Tel: 01903 737756
Email: planning@arun.gov.uk
www.arun.gov.uk/planning
Please ask for: Laura Mills
Email: laura.mills@arun.gov.uk
Telephone: 01903737794
Our Ref: EP/55/26/HH
Your Ref:
Date: 5th June 2026

Application for Planning Permission for Works or Extension to a Dwelling

Development: Replacement of first floor rear glazing.
Location: Vista Point 21 Tamarisk Way East Preston BN16 2TE

REVISION	DATE
A	03/05/26
MINOR AMENDMENTS	02/06/26
PROJECT ADDRESS	
VISTA POINT, 21 TAMARISK WAY	
EAST PRESTON, LITTLEHAMPTON BN16 2TE	
DRAWING	
PROPOSED PLAN AND ELEVATIONS	
SCALE	
1:100 @ A1	
DRAWING No.	
2105 3PA01

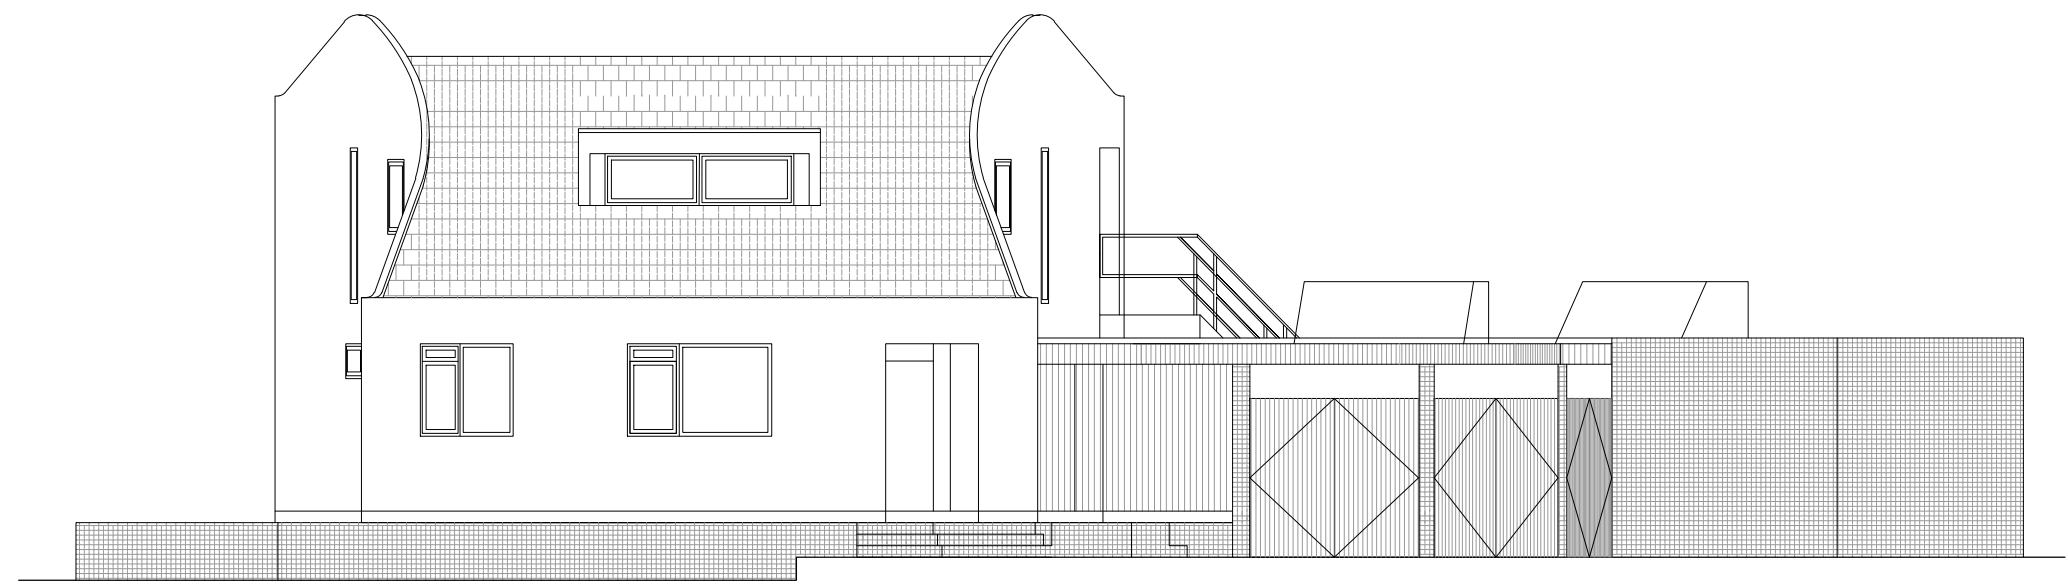
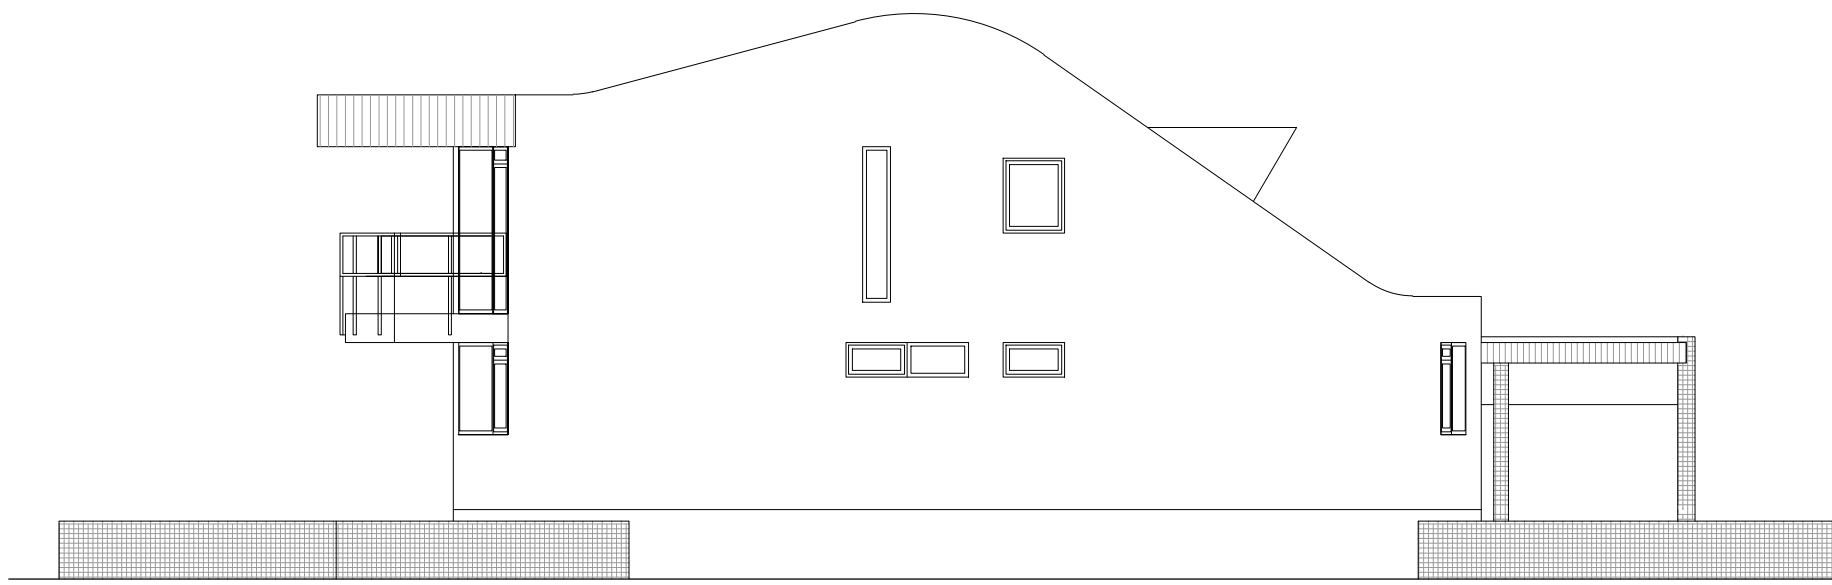
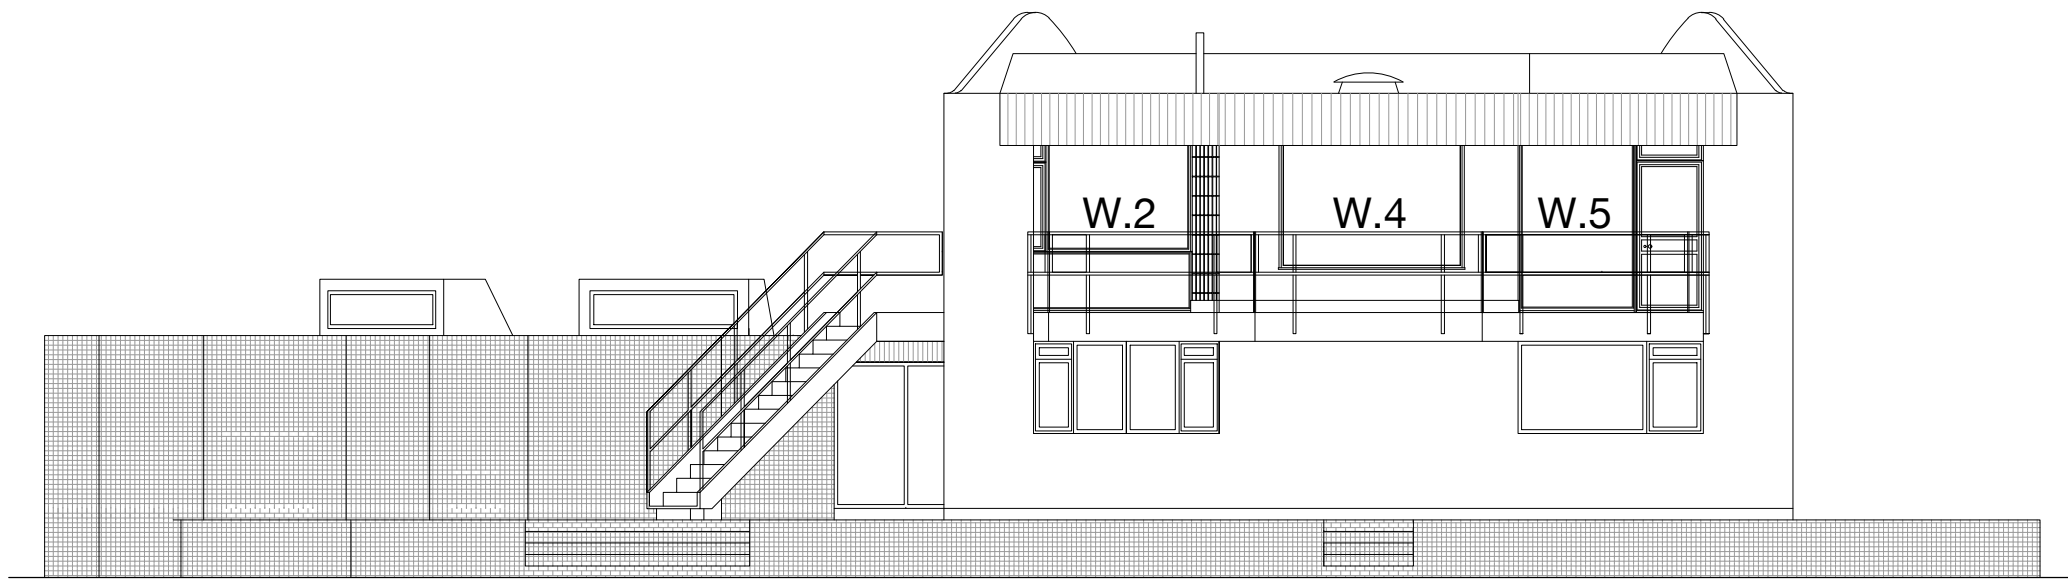
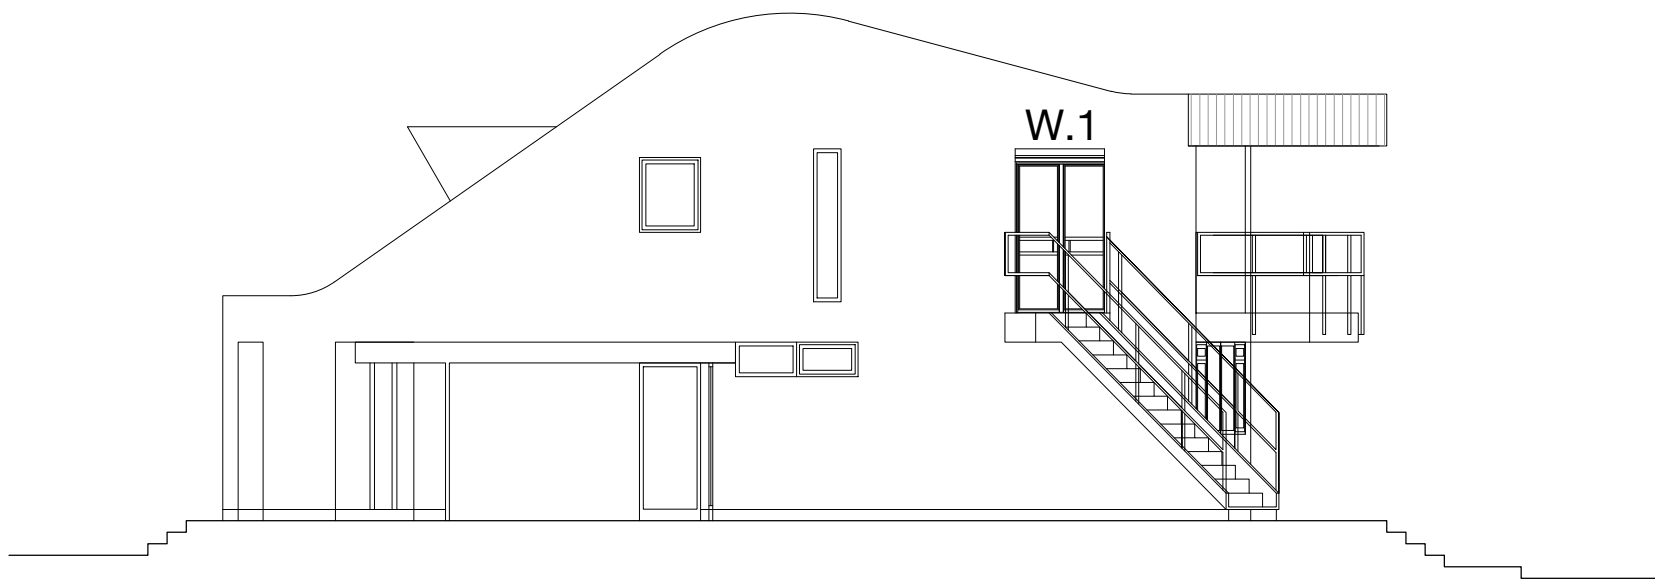
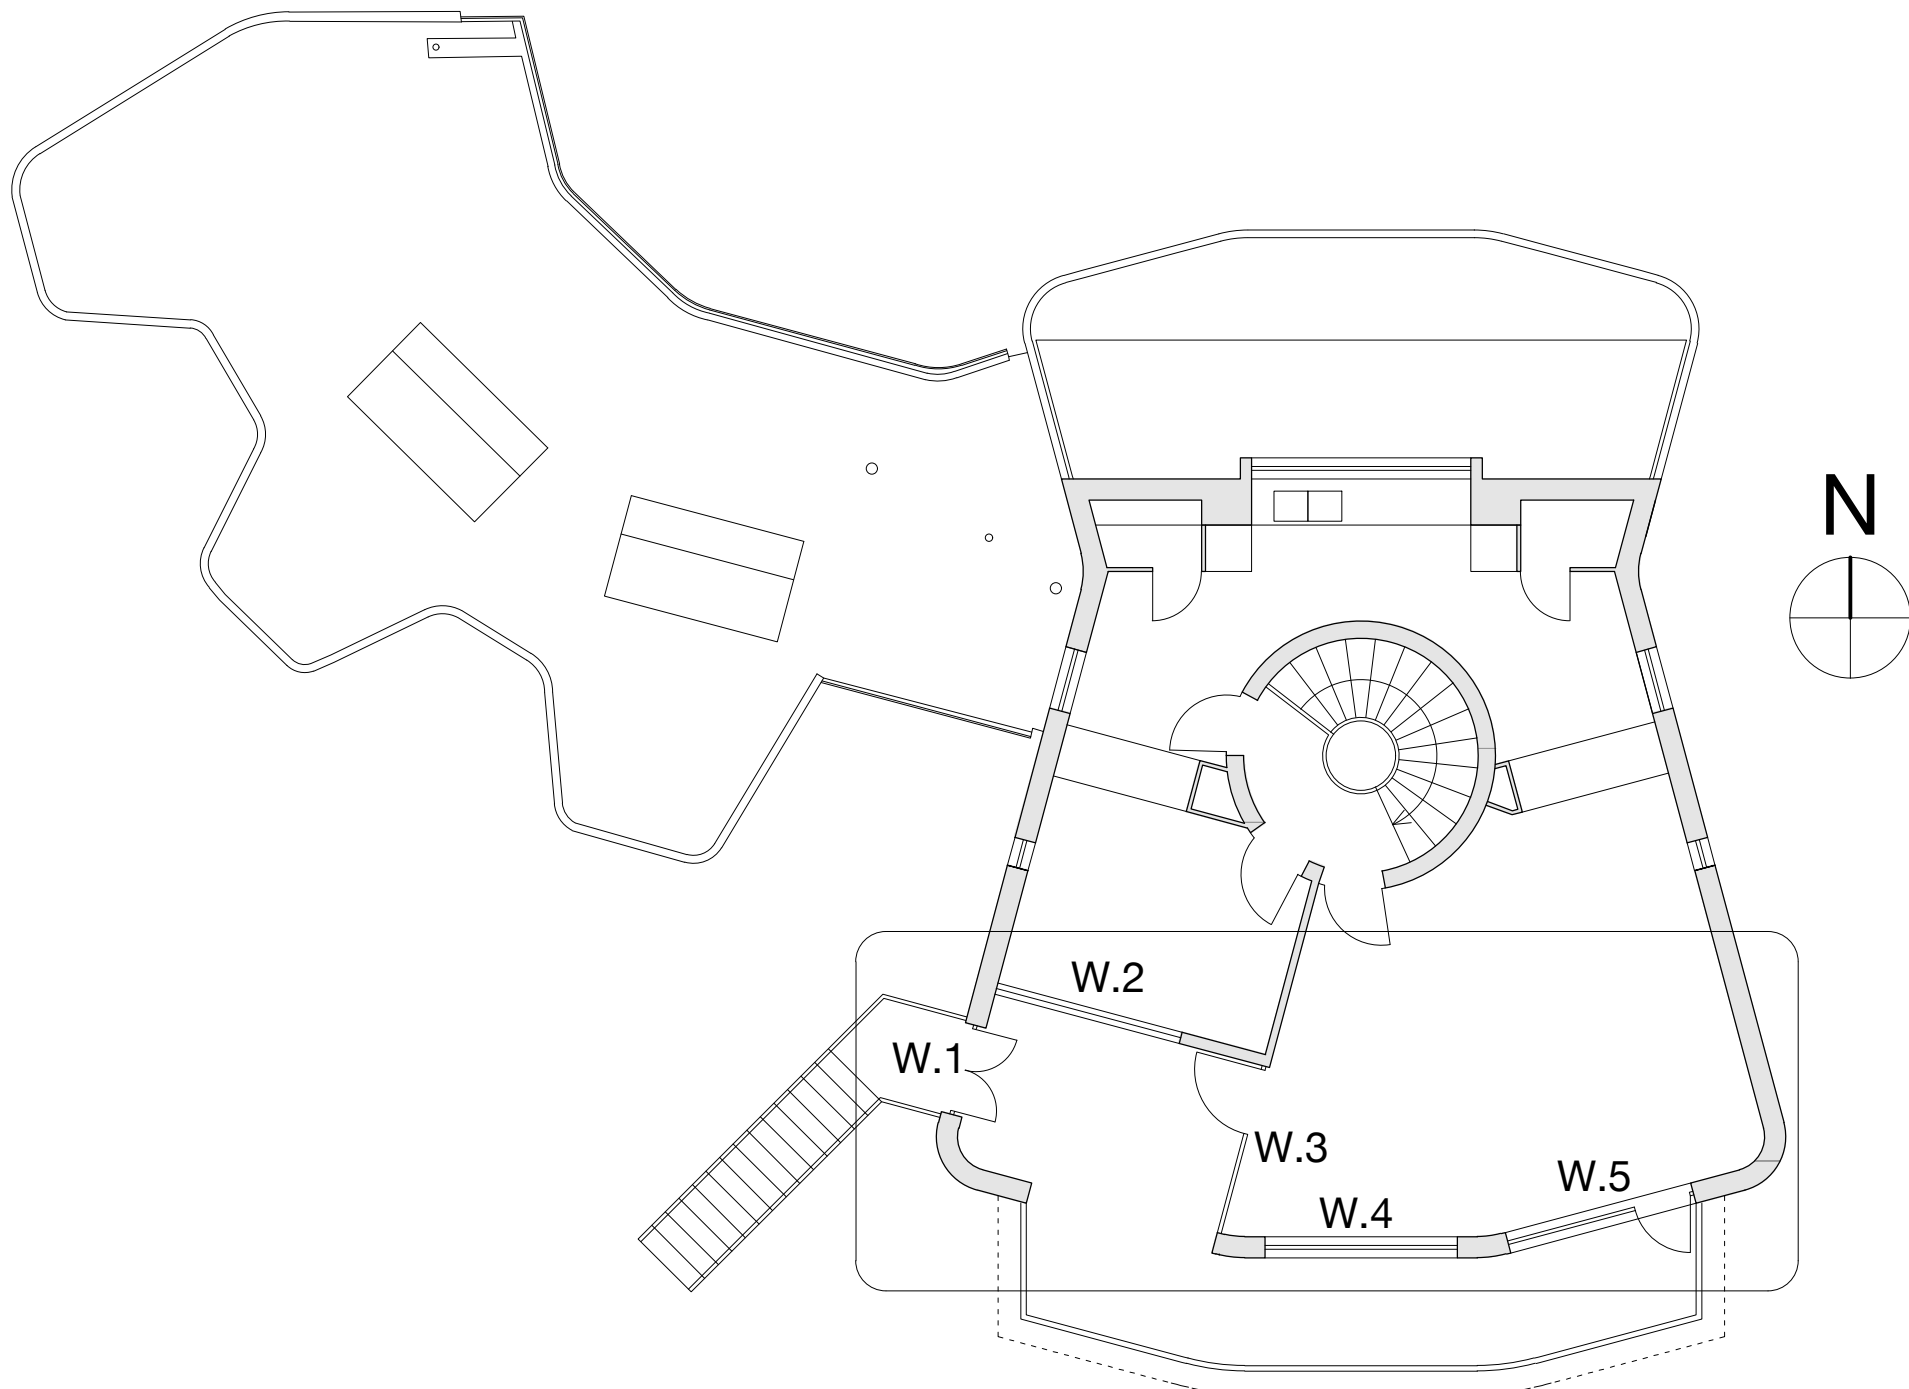
The scale bars on the proposed and existing elevation plans do not scale at 1:100. Existing and proposed elevations should either be 1:50 or 1:100.

DRAWING No.
2105 3SC03.1

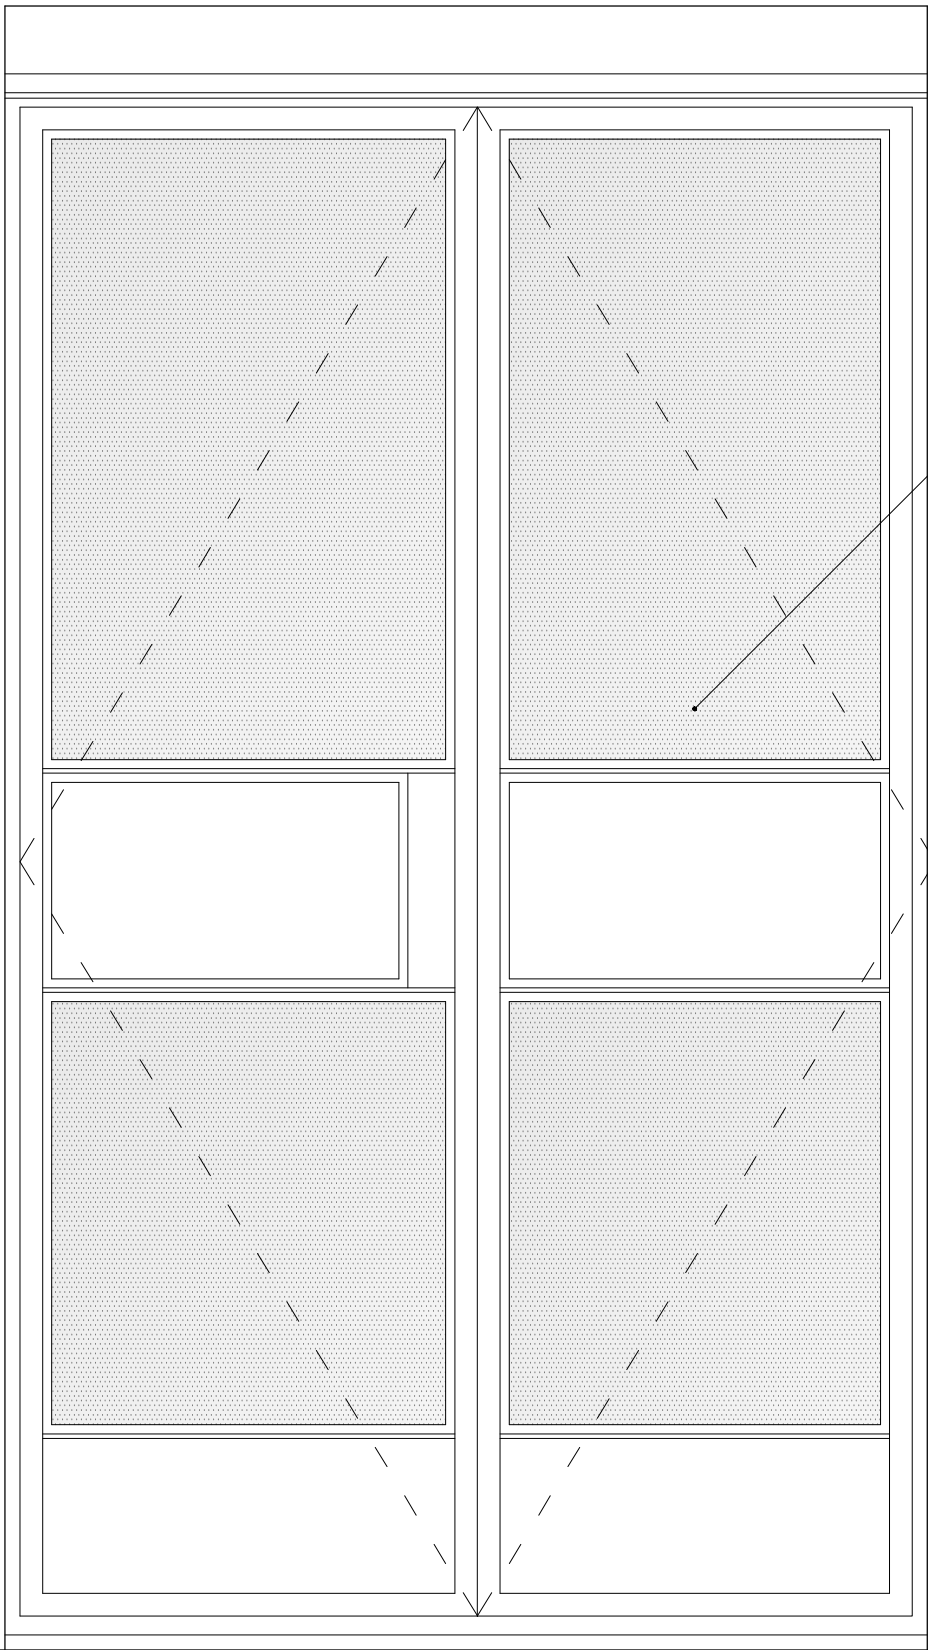
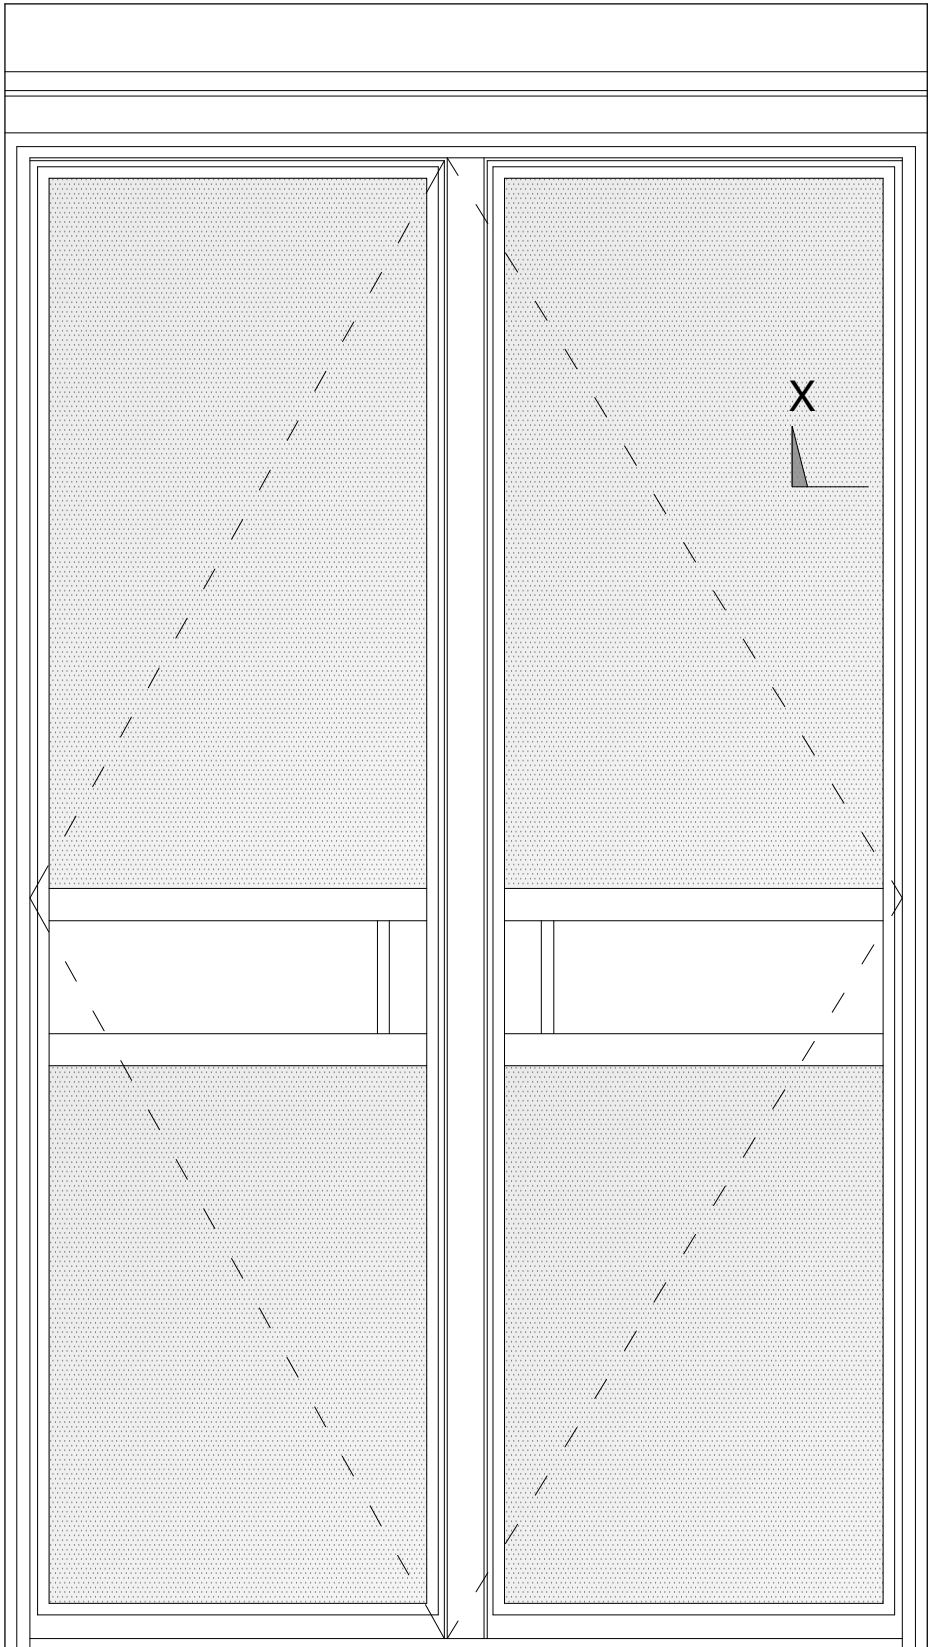
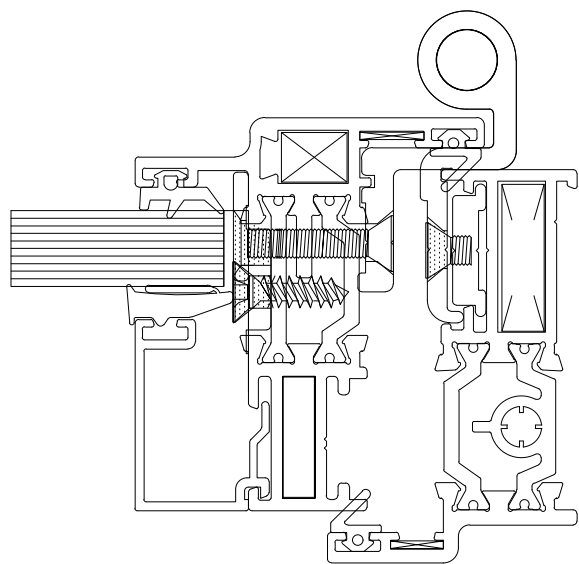
The scale bar does not scale at 1:10 and the plans should be provided to a scale of not less than 1:20.
